Item No. **Report of the Interim Director of Planning, Regeneration & Public Realm**

Address 20 NICHOLLS AVENUE HILLINGDON

Development: Demolition of existing building and erection of 1 x 2-storey dwelling, incorporating basement.

LBH Ref Nos: **28460/APP/2022/1536**

PL-07

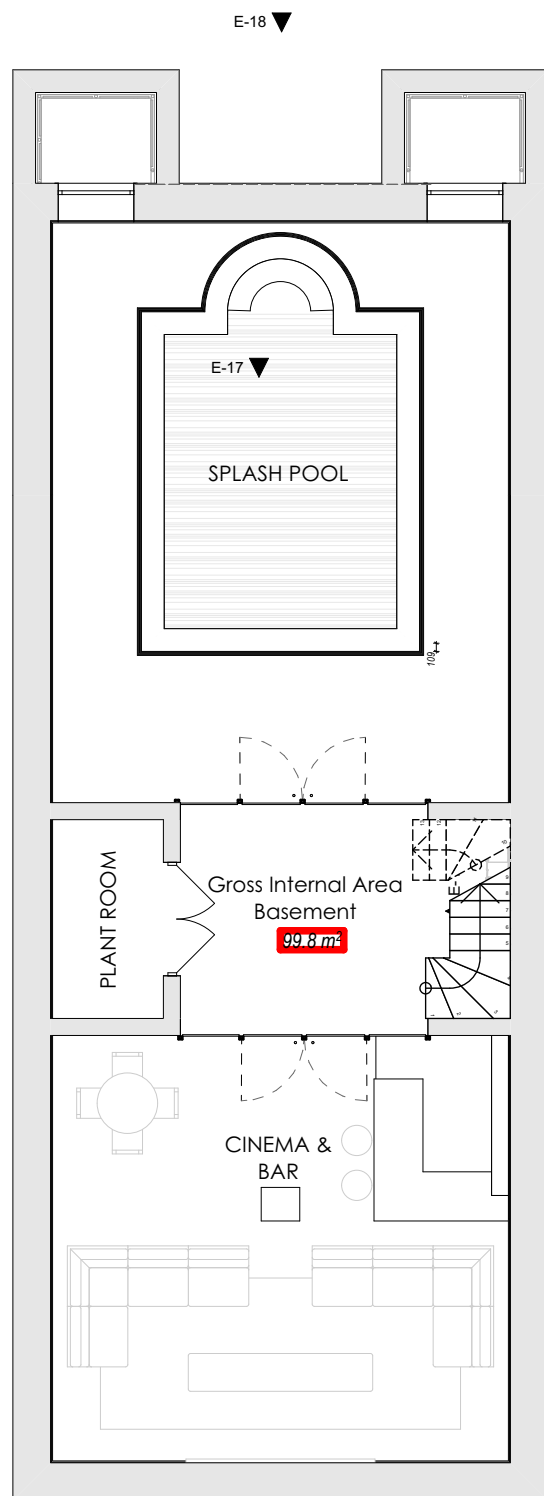
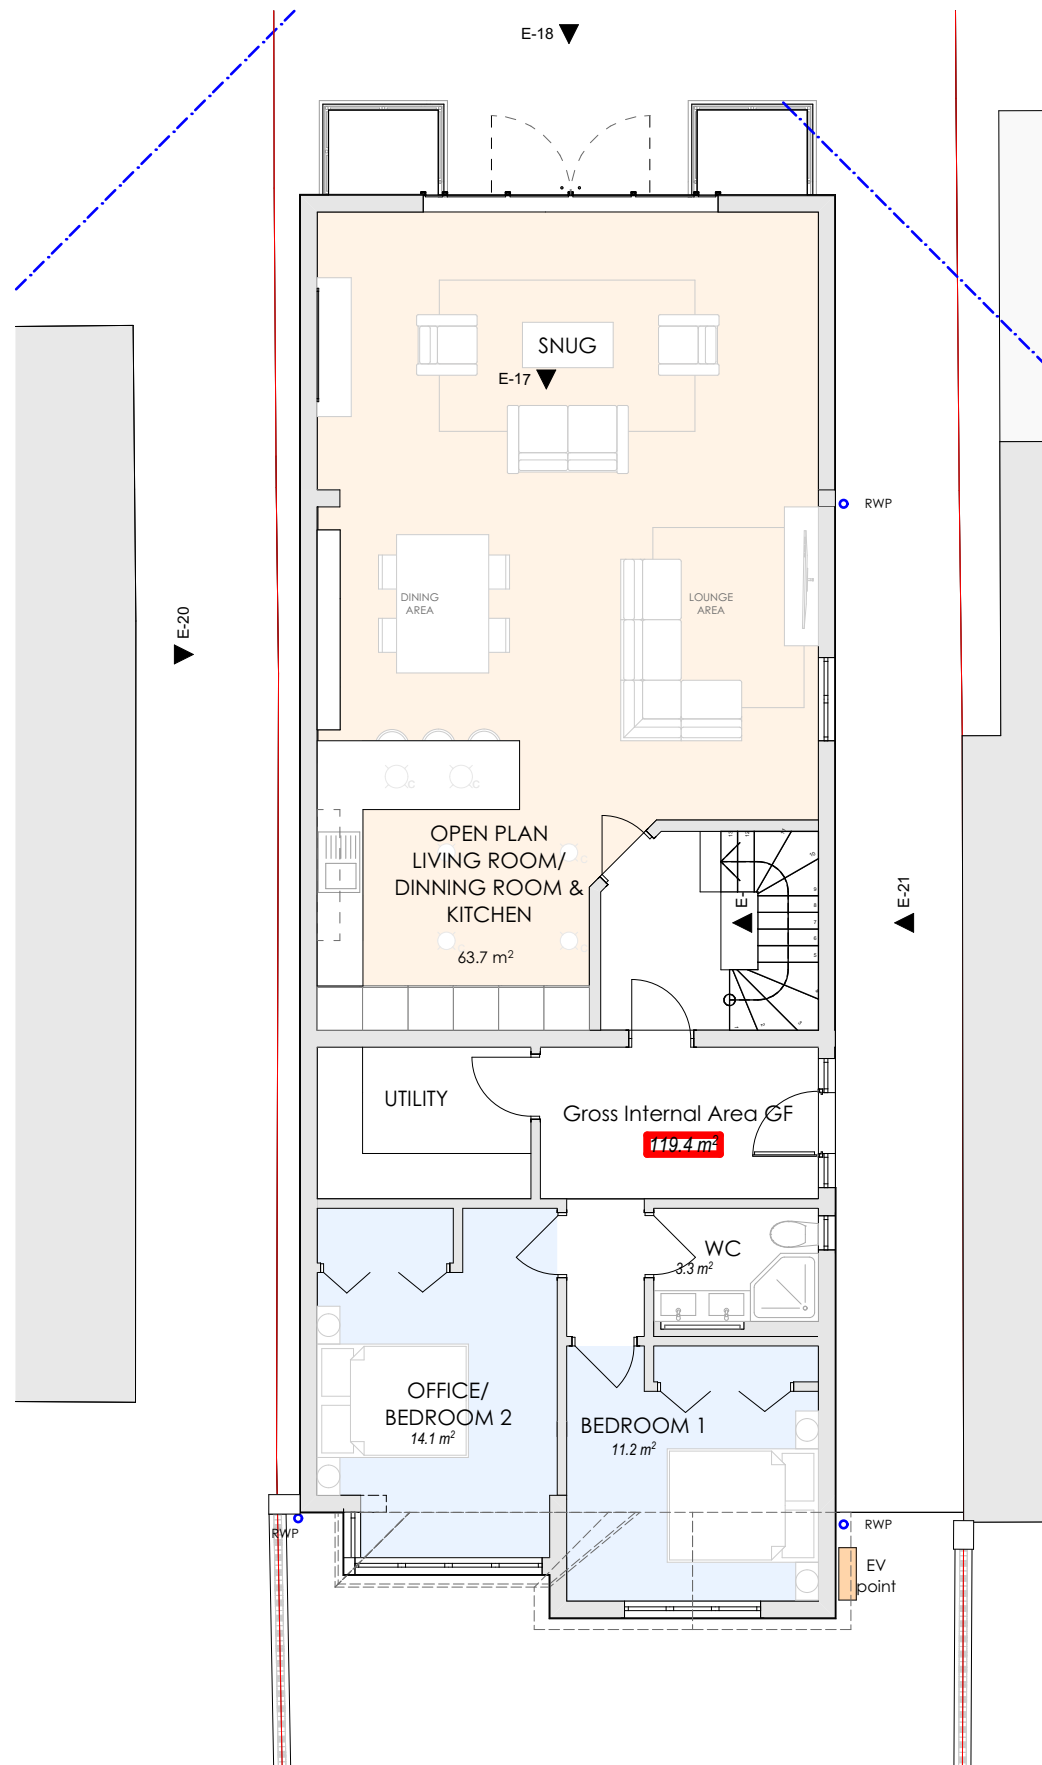
The site lies within a Critical Drainage Area. The proposal includes a basement level which could increase flood risk. The applicant has submitted a Basement Impact Assessment and an FRA and Drainage Strategy which demonstrates that the proposal would not, subject to appropriate drainage and mitigation measures, have an adverse impact on flooding. In the event of an approvable scheme, suitable conditions could be imposed.

PL-08

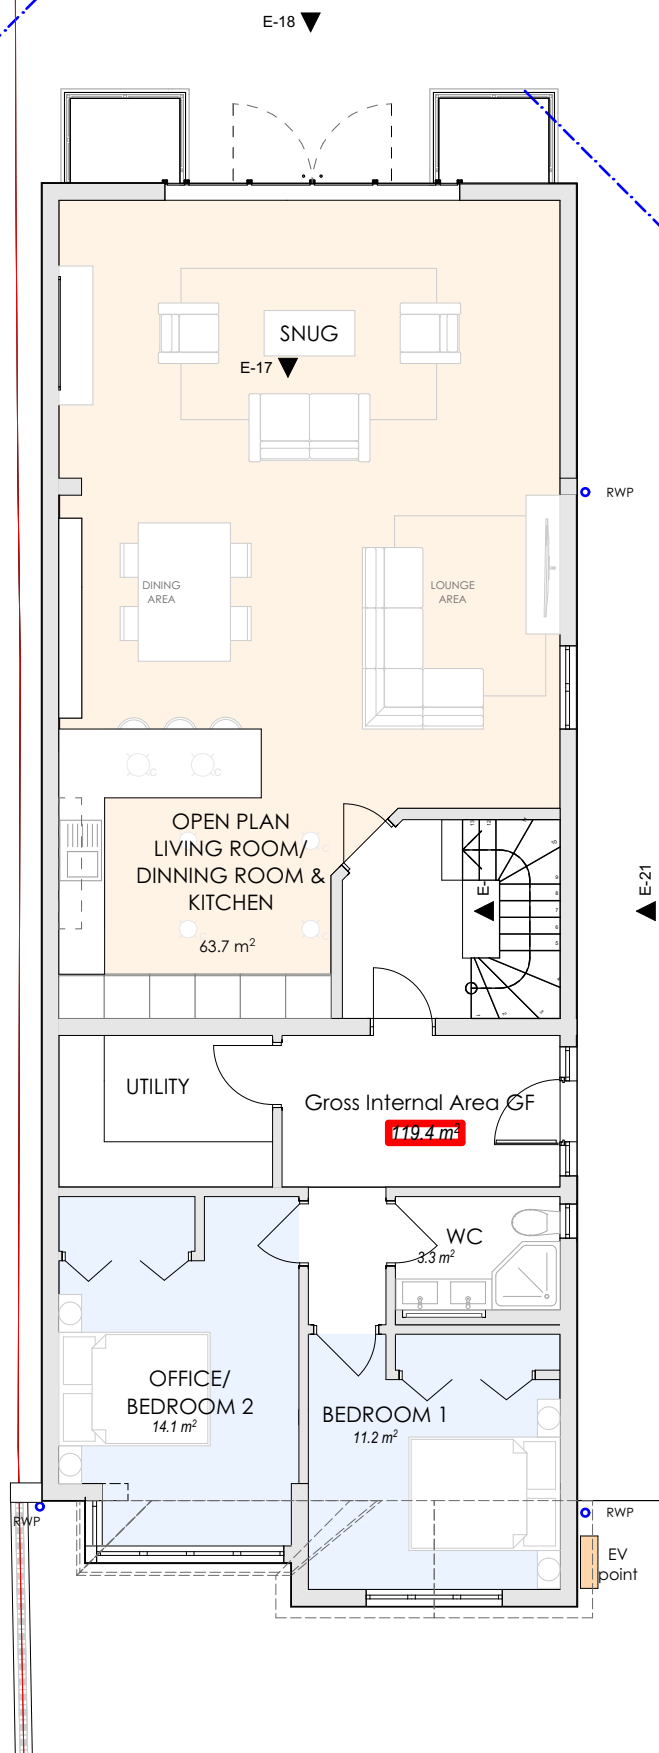
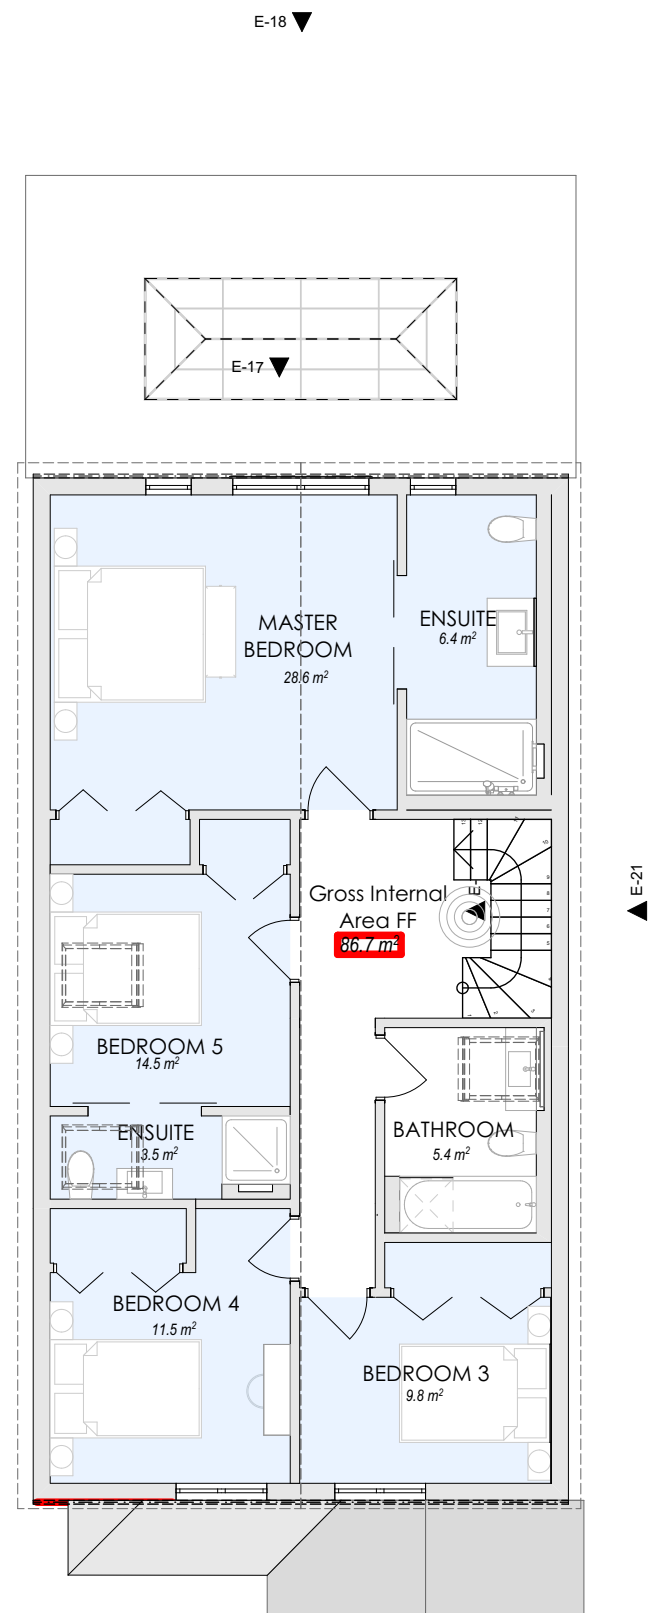
The proposed development has failed to demonstrate that it would provide an adequate level of outlook for the future occupiers of bedroom 5 due to its reliance solely on rooflights, which are set at a high level. The proposal would therefore give rise to a substandard form of living accommodation to the detriment of the amenities of future occupiers contrary to Policy DMHB 11 of the Hillingdon Local Plan: Part Two - Development Management Policies and Policy D6 of the London Plan (2021).

Concerns were received in respect of the previous application that the bedroom 5 would not be served by any window providing a level of outlook for this habitable room. The current proposal fails to address this concern and as such, the proposed development has failed to demonstrate that it would provide an adequate level of outlook for the future occupiers of BEDROOM 5 due to its reliance solely on rooflights, which are set at high level. The proposal would therefore give rise to a substandard form of living accommodation to the detriment of the amenities of future occupiers contrary to Policy DMHB 11 of the Hillingdon Local Plan: Part Two - Development Management Policies and Policy D6 of the London Plan (2021).

Drawing Date: 5.11.2021	Status: PLANNING DRAWINGS	
Issue Date: 16/05/2022	Drawn By: CM	Scale: @A3
Job No: 9078	Drawing No: PL-10	Rev:

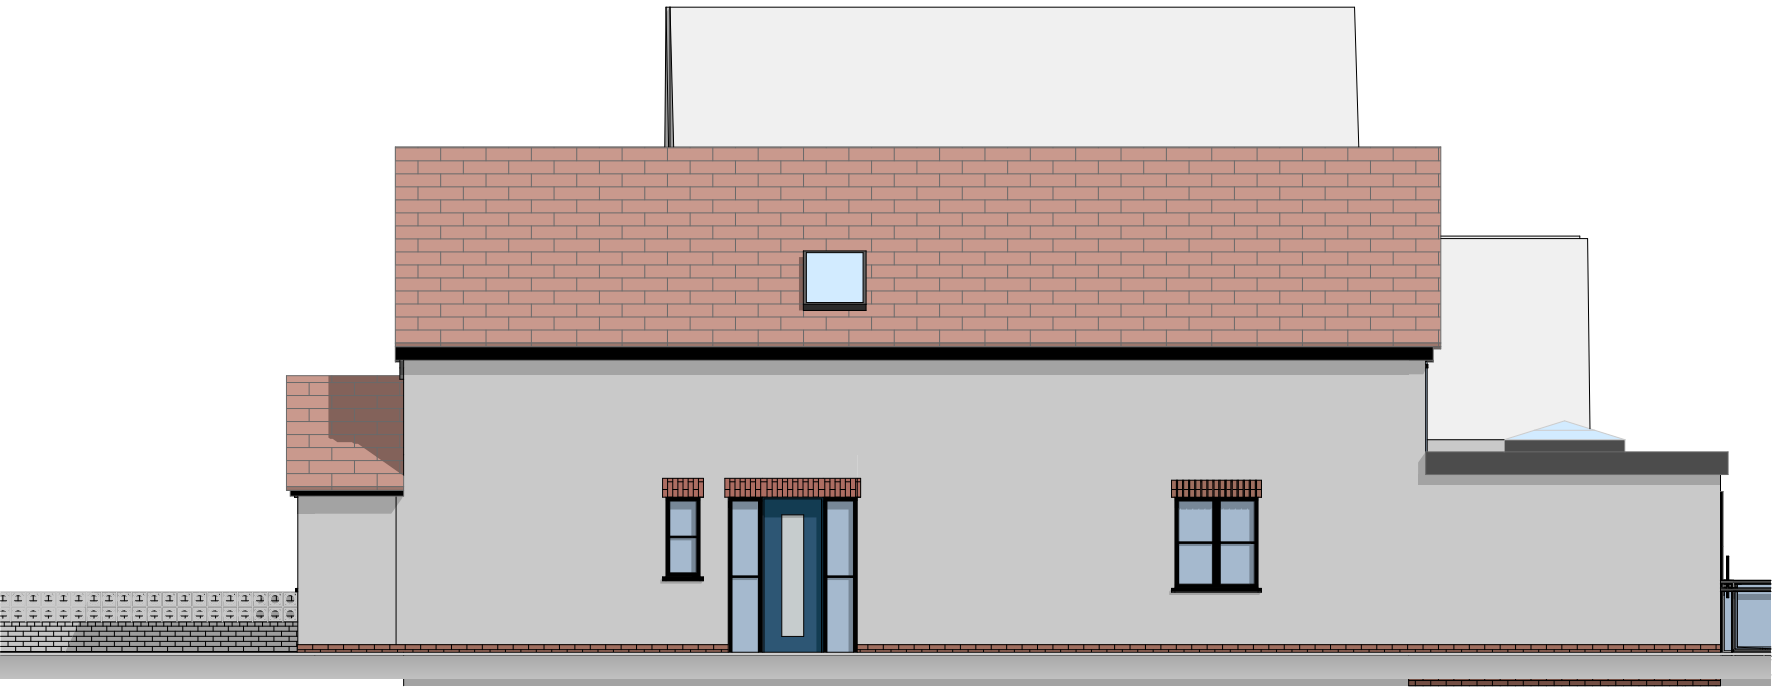
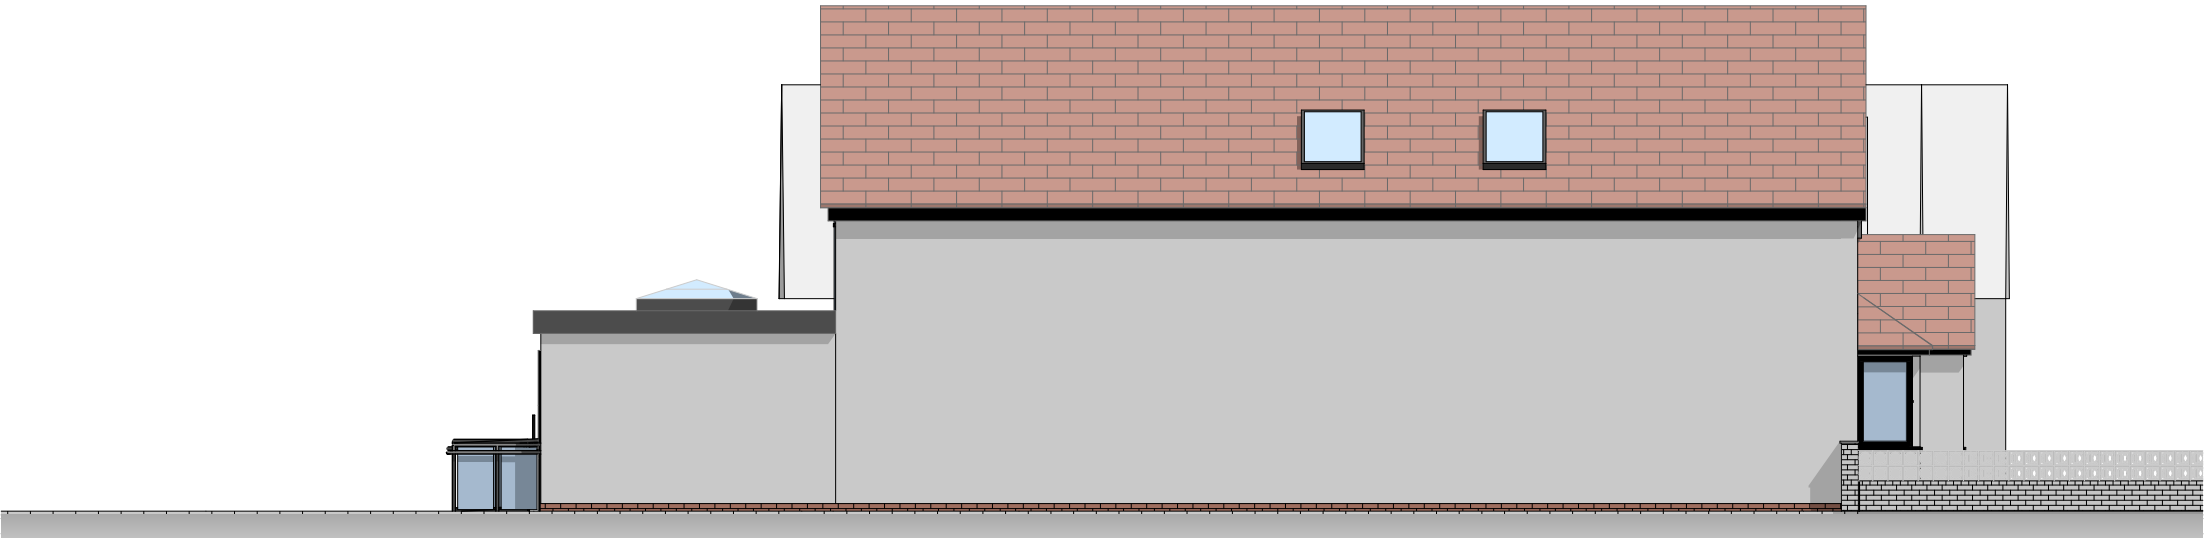
The proposed development, by virtue of its proximity, size, scale, height and design would be detrimental to the residential amenities of the neighbouring occupiers at No.22 Nicholls Avenue, in terms of loss of light, outlook, overshadowing, sense of enclosure and overbearing effect. The proposal would therefore be contrary to Policy BE1 of the Hillingdon Local Plan: Part One - Strategic Policies (2012) and Policy DMHB 11 of the Hillingdon Local Plan: Part Two- Development Management Policies (2020).

No. 22 is a detached chalet bungalow which has been previously extended within the roofspace and to the rear. The layout of this bungalow is such that there is a side facing window (facing the application site) serving a habitable room at ground floor level. It is considered that the provision of an additional storey at the application site would be detrimental to the residential amenities of the neighbouring occupiers at No.22 Nicholls Avenue, having particular regard to the impact on the existing habitable ground floor bedroom, in terms of loss of light, outlook, overshadowing, sense of enclosure and overbearing effect.

Drawing Date: 5.11.2021	Status: PLANNING DRAWINGS	
Issue Date: 16/05/2022	Drawn By: CM	Scale: @A3
Job No: 9078	Drawing No: PL-18	Rev:

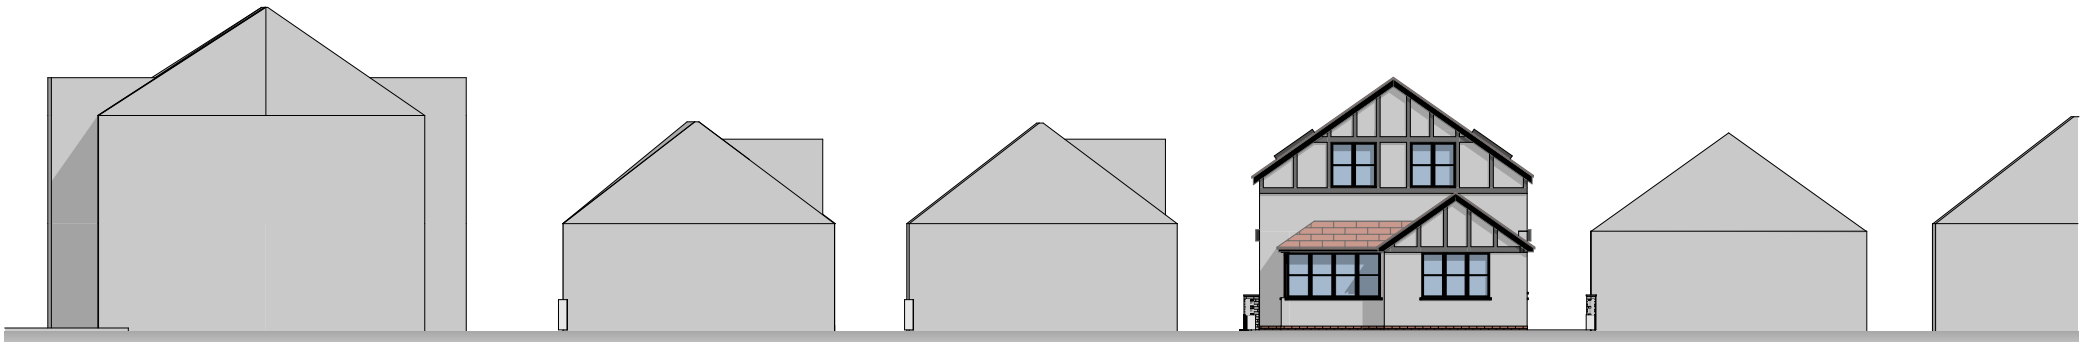
The proposed development by reason of its size, scale, bulk, massing, materiality and design would result in an incongruous and visually intrusive form of development that would fail to harmonise with the established built environment and rhythm of development between Nos.2 and 24 Nicholls Avenue resulting in a detrimental impact on the character and appearance of this part of Nicholls Avenue. The proposal would therefore be contrary to Policy BE1 of the Hillingdon Local Plan: Part One - Strategic Policies (2012), Policies DMHB 11, DMHB 12 and DMHD 1 of the Hillingdon Local Plan: Part Two- Development Management Policies (2020).

considered that the dwelling would fail to harmonise with the established built environment and rhythm of development between Nos.2 and 24 Nicholls Avenue resulting in a detrimental impact on the character and appearance of this part of Nicholls Avenue. The proposal would therefore be contrary to Policy BE1 of the Hillingdon Local Plan: Part One - Strategic Policies (2012), Policies DMHB 11, DMHB 12 and DMHD 1 of the Hillingdon Local Plan: Part Two- Development Management Policies (2020). The benefits do not outweigh the harm identified.
